LU/240/20/PL

Felix Dancewear 39 Beach Road Littlehampton BN17 5JA - Demolish existing out buildings & replace with rear extension

Dwg No. BEA/002

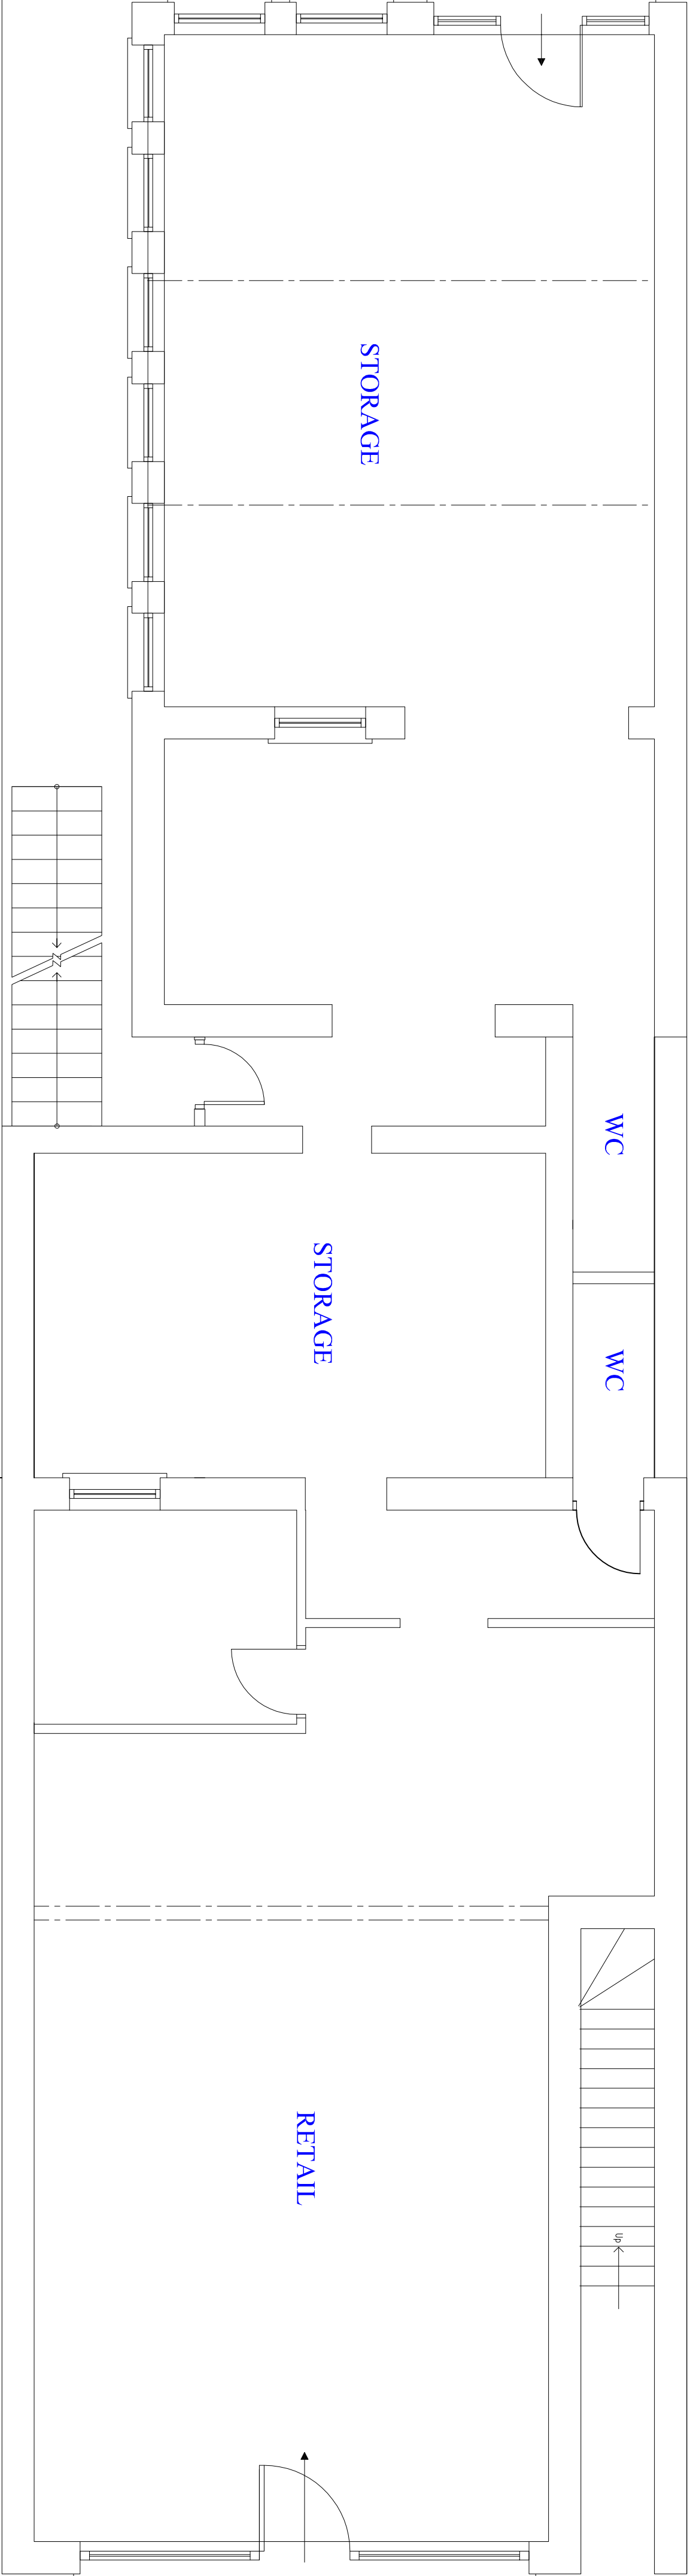
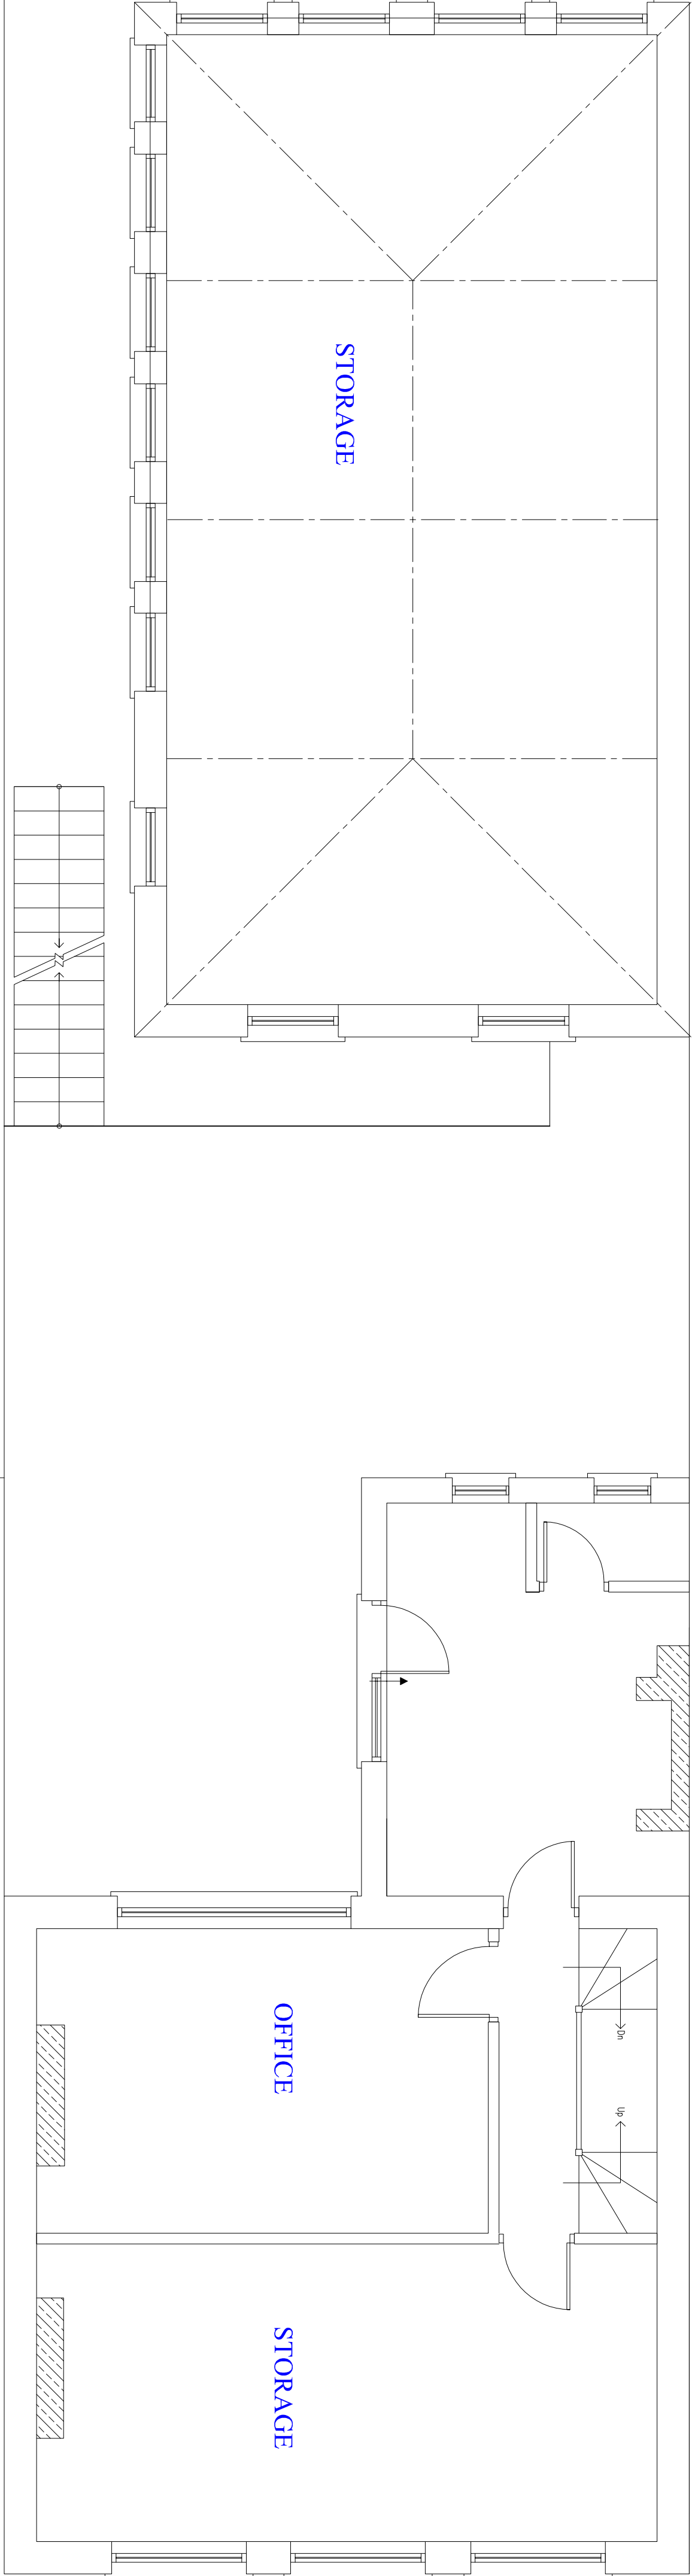
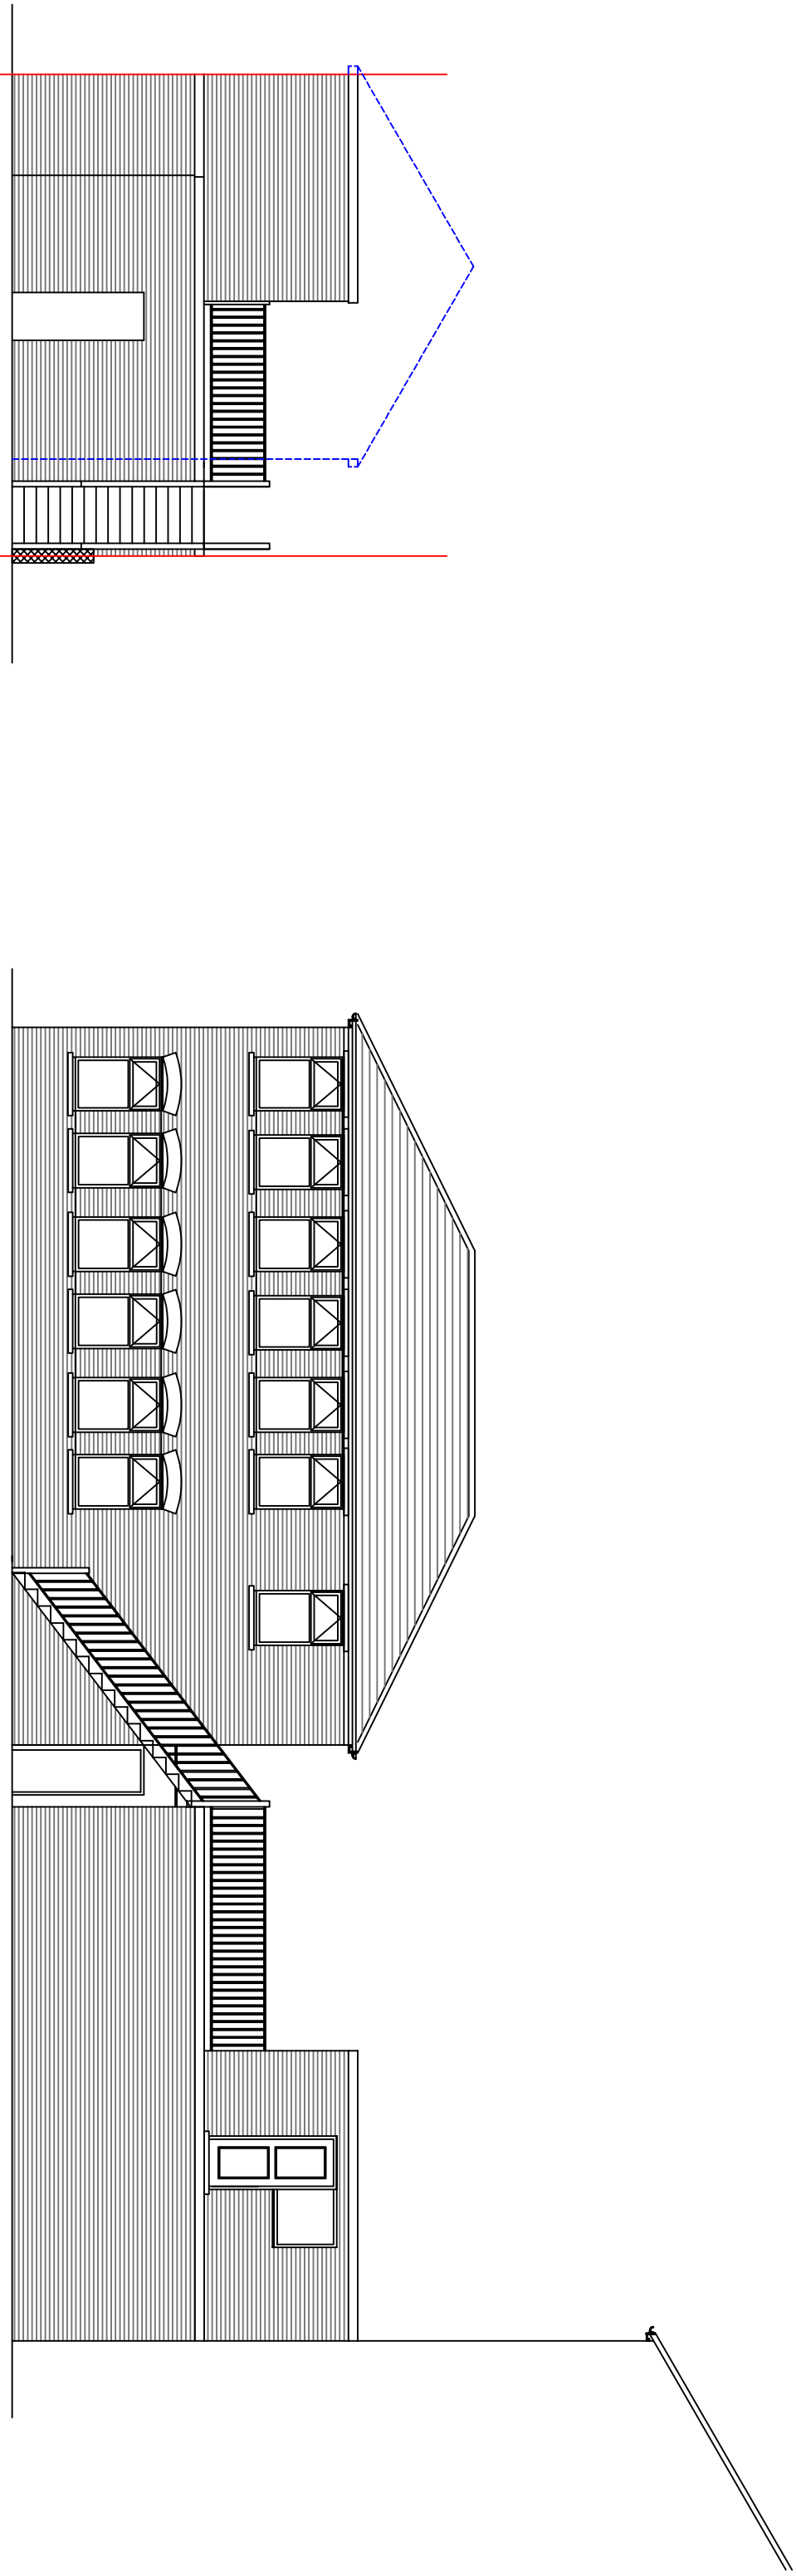
corrugated sheeting. As a consequence, their loss will not harm the character of the building. Further, it is also considered that the replacement extension will have a neutral impact on the building due to its location and simple appearance. This is, of course, subject to the use of appropriate materials. The application should therefore be determined in accordance with the relevant policies within the Development Plan, along with these comments.
